MECKLENBURG COUNTY
Park and Recreation Department

MEMORANDUM

DATE: June 30, 2020

RE: Rezoning Petition #2020-019 – Plaza Road Townhomes

REZONING CONCEPT PLAN
RZ-1

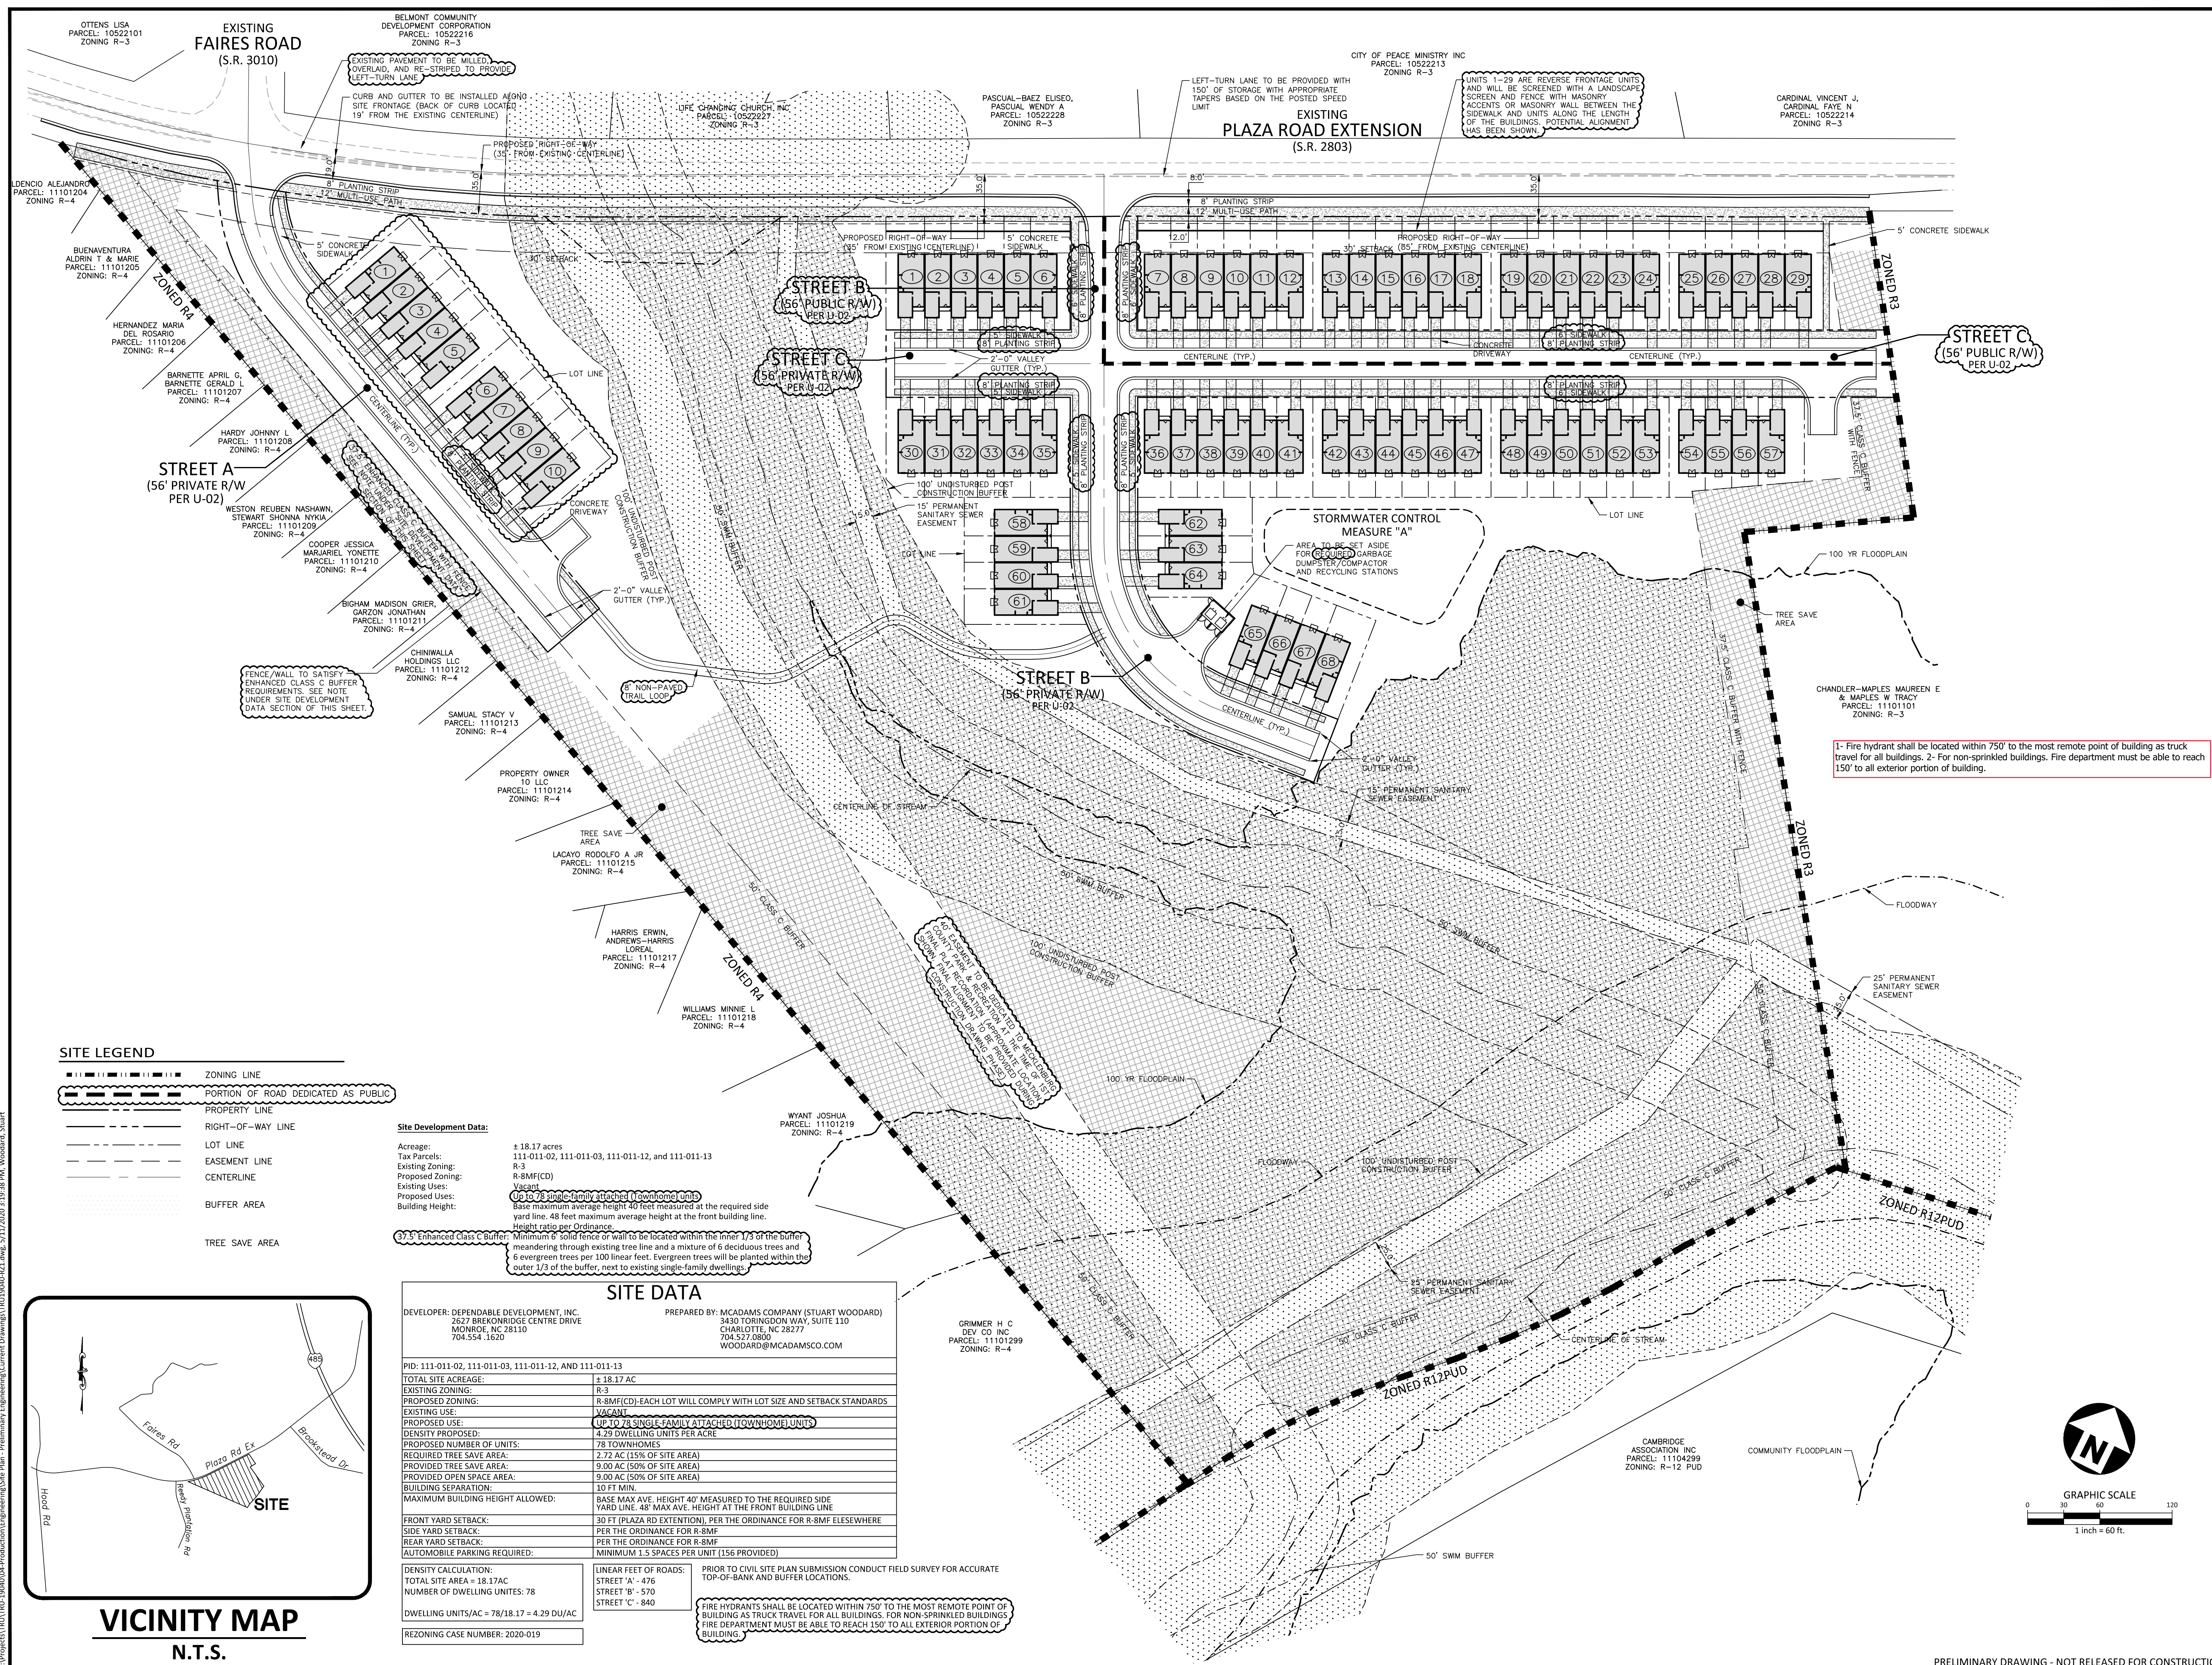
MCPR requests the petitioner provide a minimum 8' wide paved, bike/ped connection to the adjacent future Reedy Creek Greenway or a minimum 40' wide Access Easement to the creek to be dedicated to Mecklenburg County.
